Application Ref:	3/2026/0191			 Ribble Valley Borough Council www.ribblevalley.gov.uk
Date Inspected:	26/06/26	Site Notice:	26/06/26	
Officer:	LW			
DELEGATED ITEM FILE REPORT:				APPROVAL

Development Description:	Proposed removal of conservatory at rear and replace with single storey rear extension, replace hipped roof with gable to create loft space for bedroom, office and bathroom with rear dormer.
Site Address/Location:	9 Glendale Drive, Mellor, BB3 7BH.

**PROPOSED ELEVATIONS - 002**

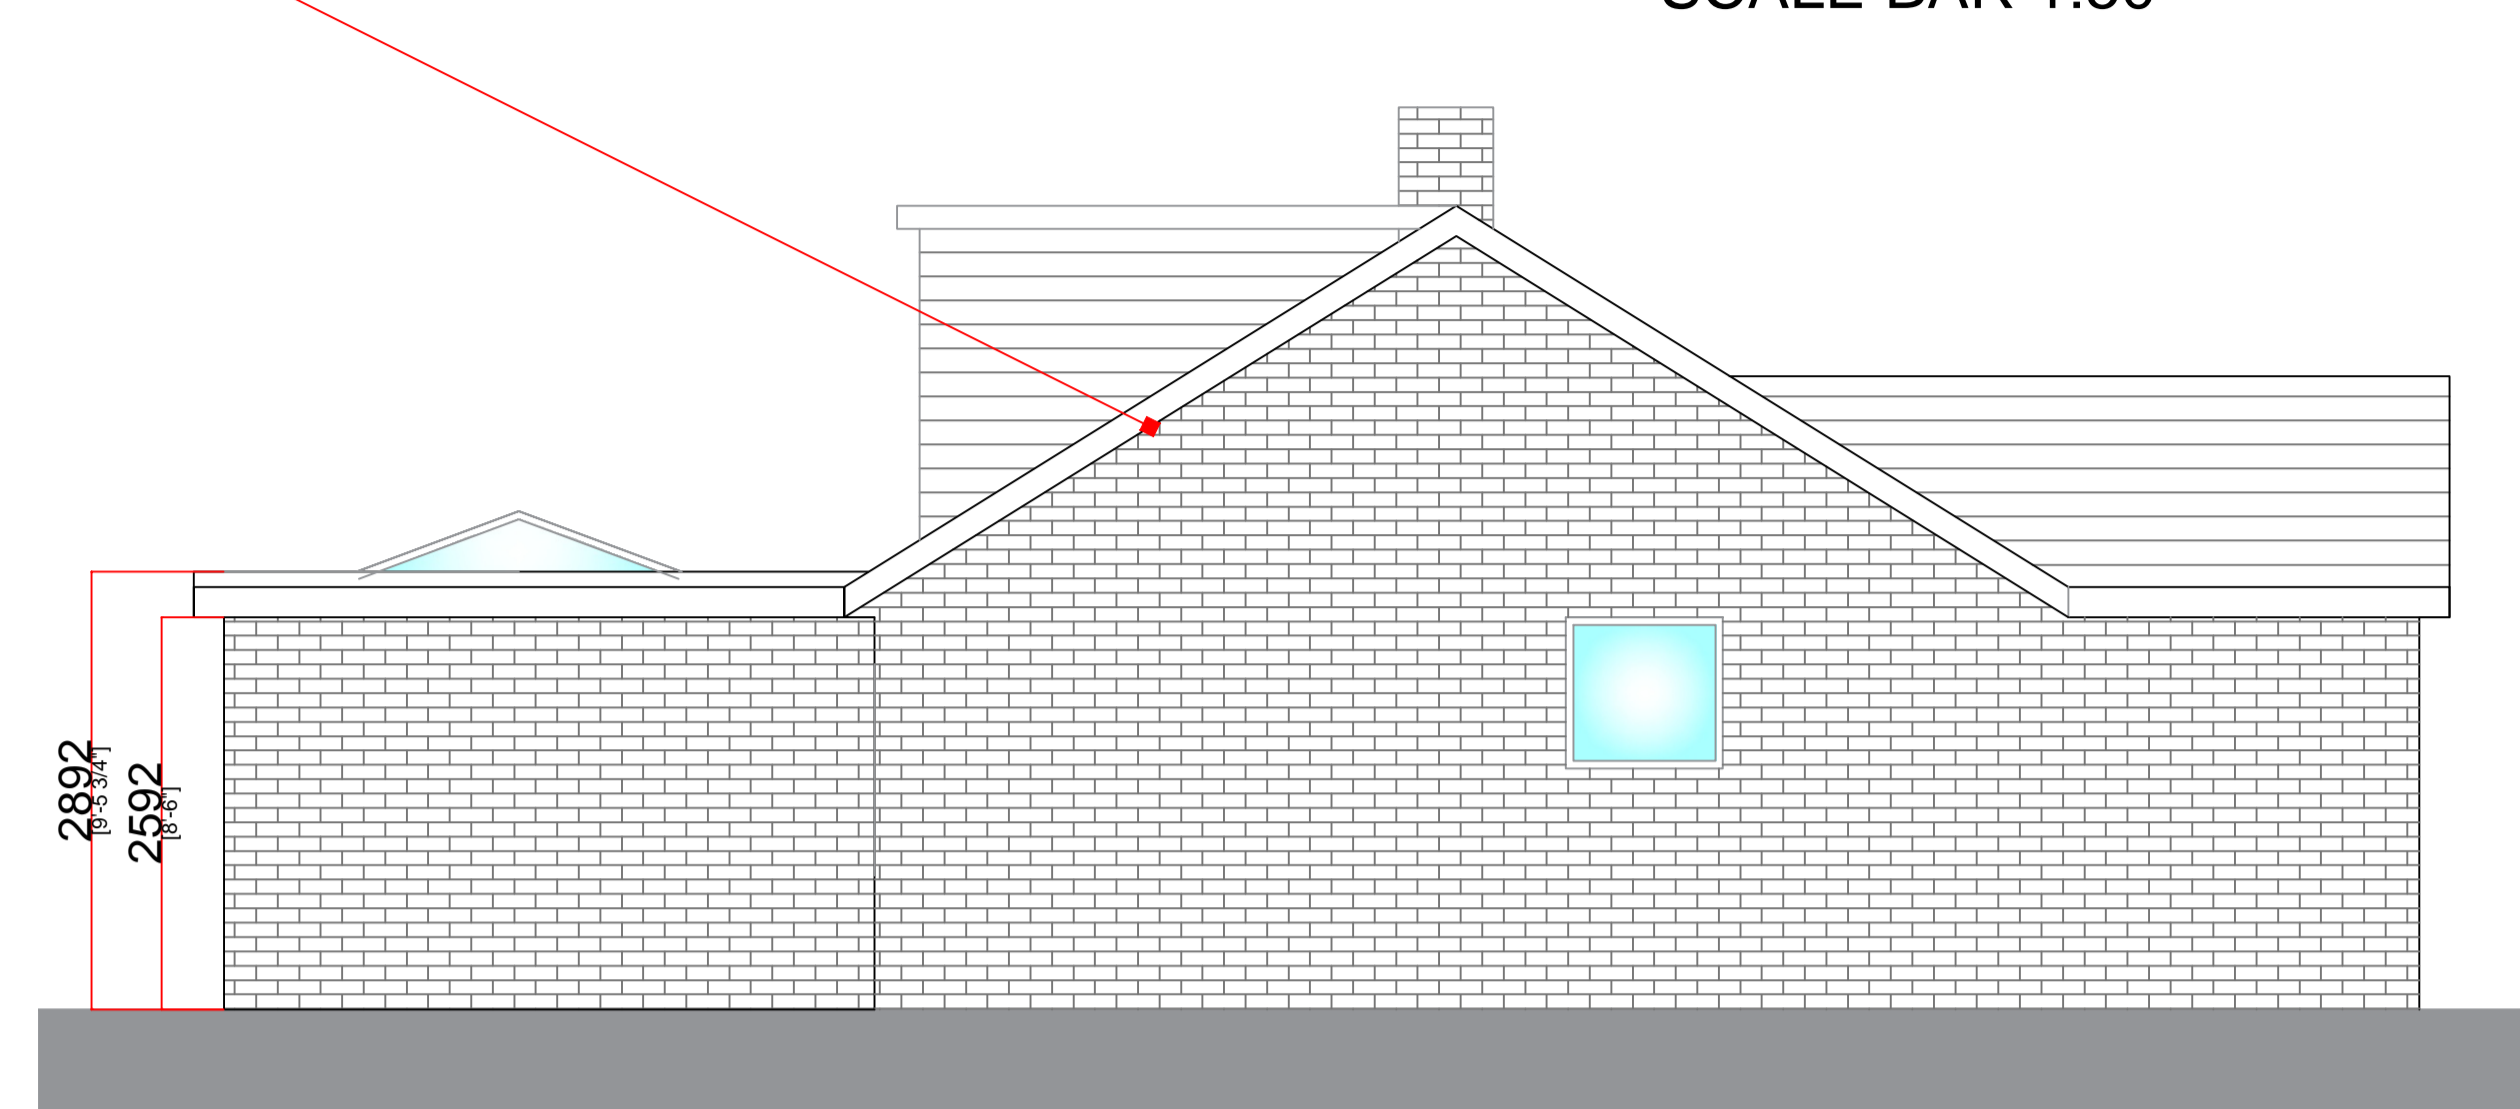
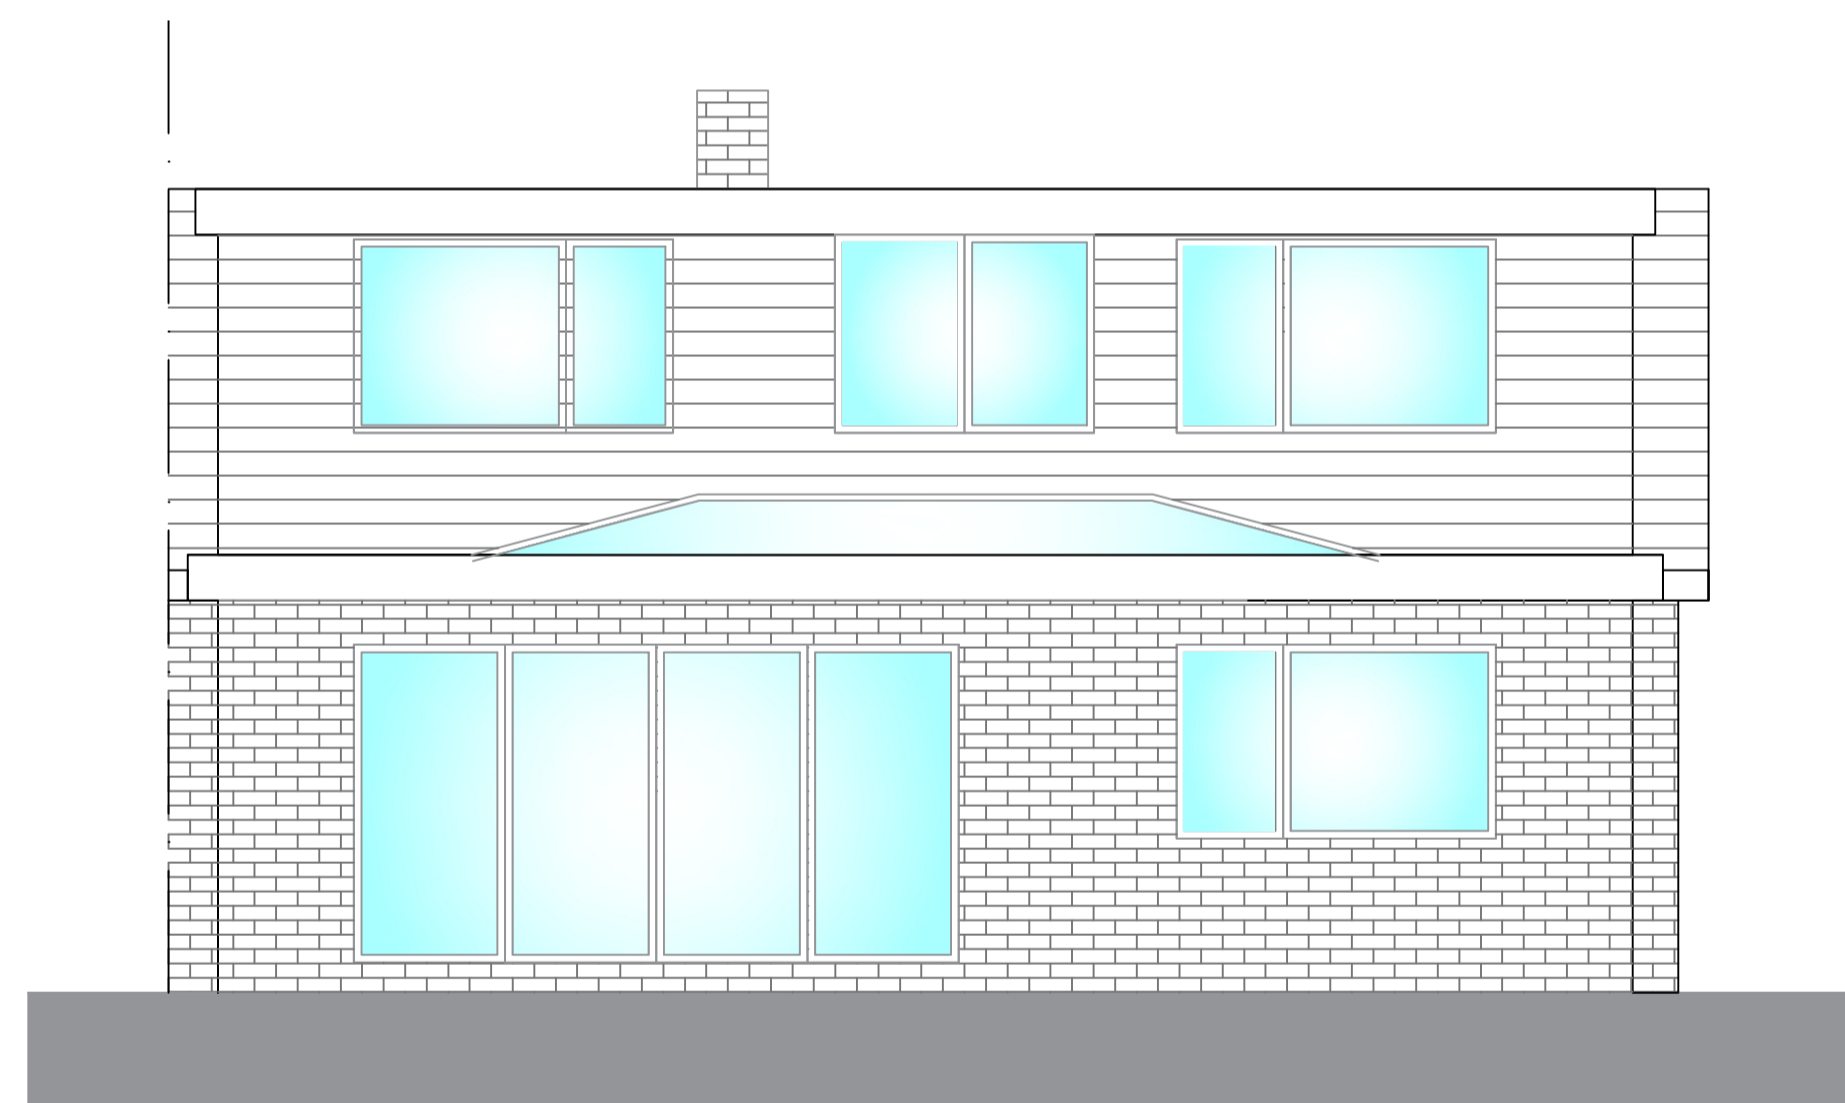
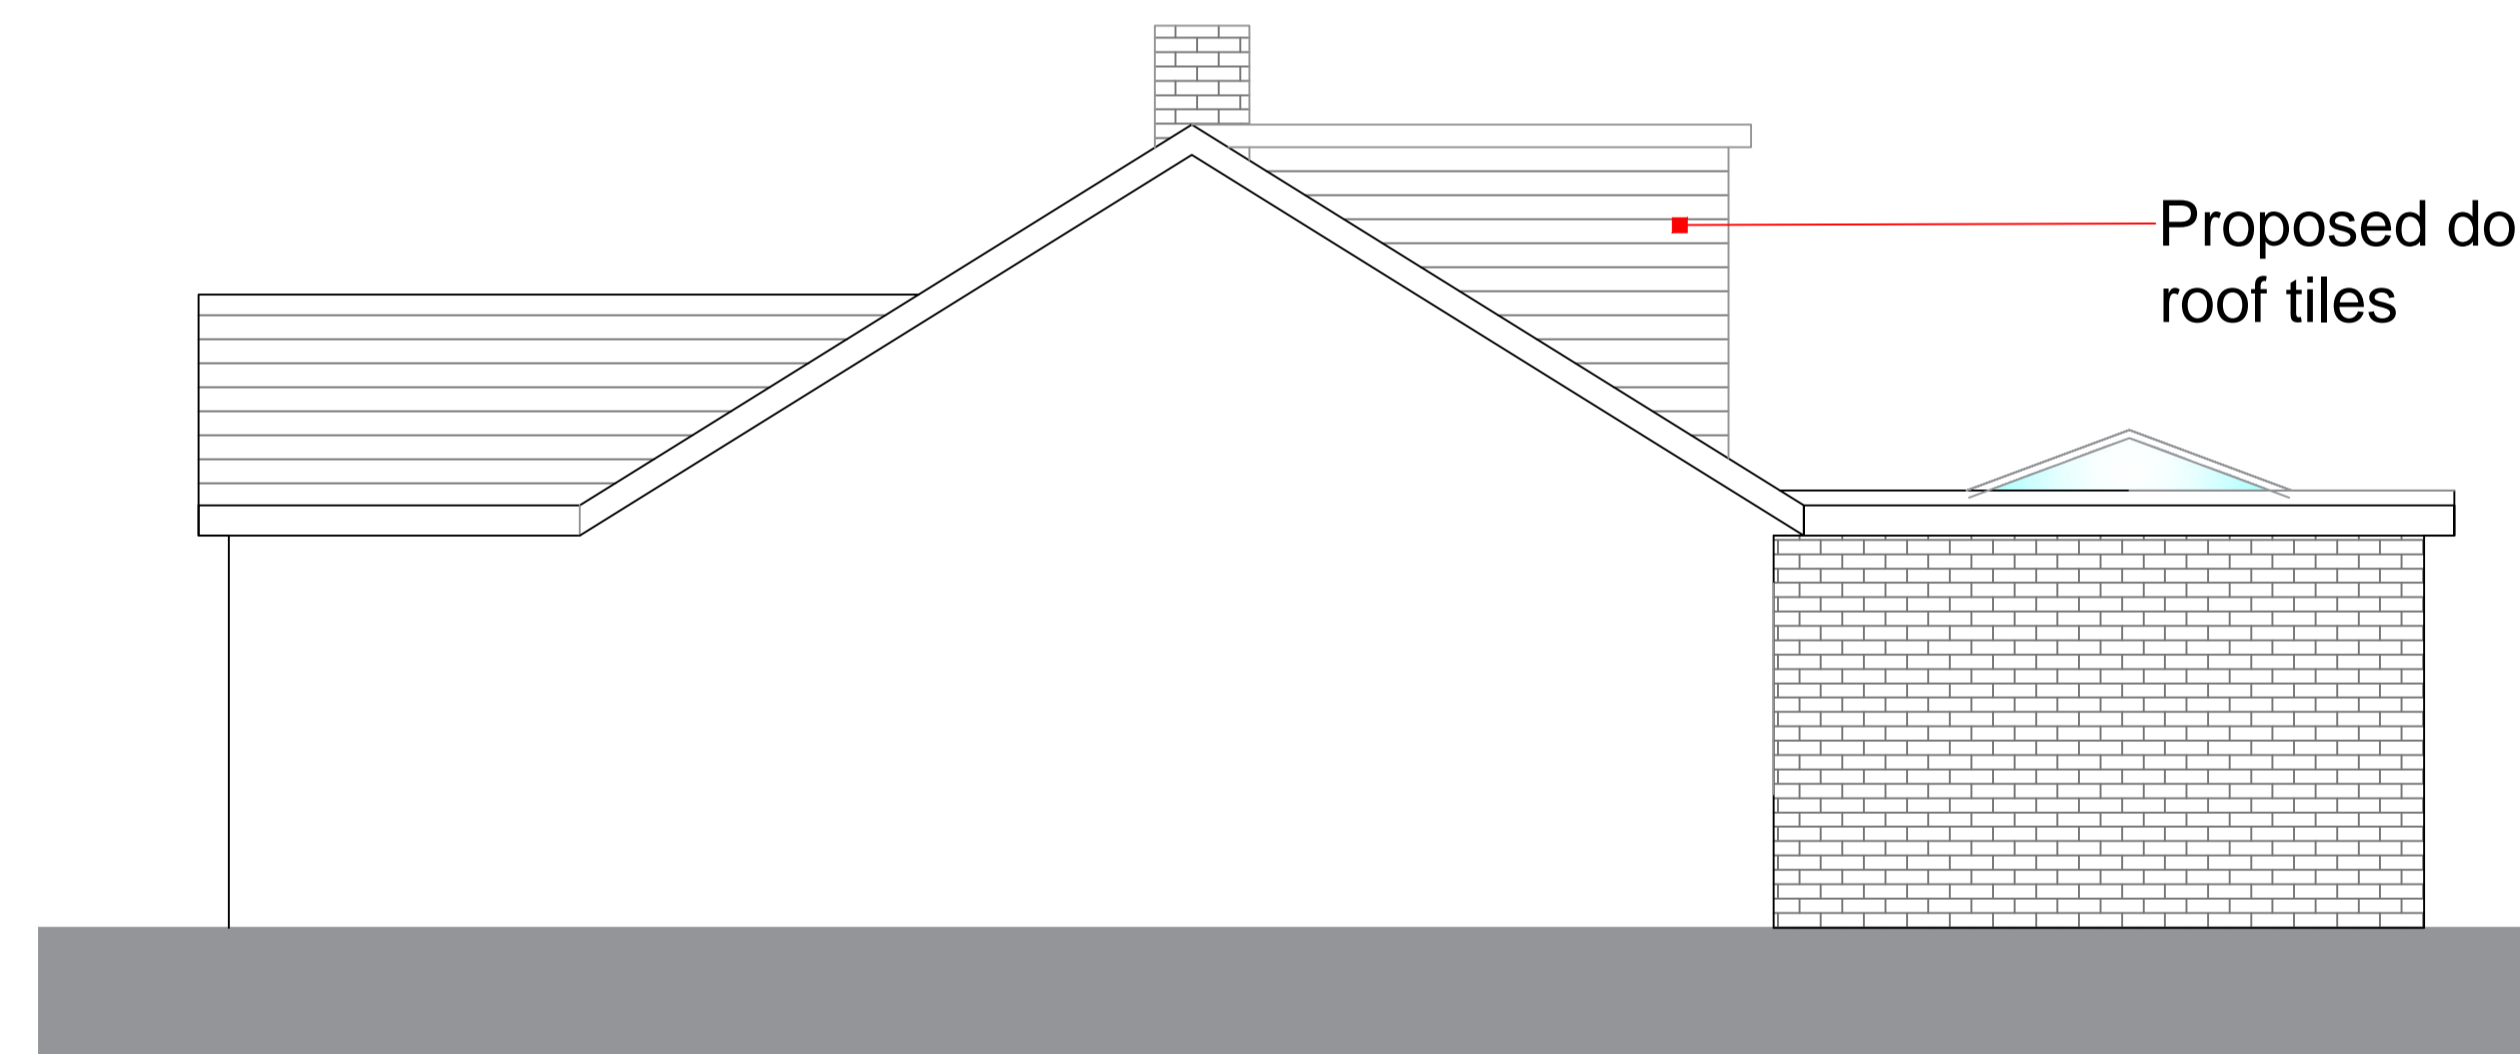
The proposed rear dormer would project approximately 3.5m from the main roof slope and measure 9.4m in width and 2.2m in height. It would include three window openings on the rear elevation.

The rear dormer windows would provide elevated views towards properties fronting Whitecroft Lane. A separation distance of approximately 19m would be maintained between the proposed development and the rear elevations of these dwellings. Whilst this falls below the typically recommended separation distance between habitable room windows, permitted development rights could allow for the construction of a similar dormer at the site without the need for express planning permission. As such, it is not considered that the proposal would give rise to a level of overlooking or loss of privacy sufficient to justify refusal of the application.

The proposed dormer would not occupy a prominent position within the surrounding area. Although it would align with the main ridge, it would be set in from the party/ end walls and positioned above the eaves. The use of materials to match the existing roof would further assist in integrating the development with the host property and minimise its visual impact. As such, it is not considered to appear unduly dominant or incongruous.

The hip-to-gable roof enlargement would be visible from the public realm; however, when viewed in the context of the wider street scene, it is considered to present a relatively minor alteration that would not result in unacceptable harm to the character or appearance of the area.
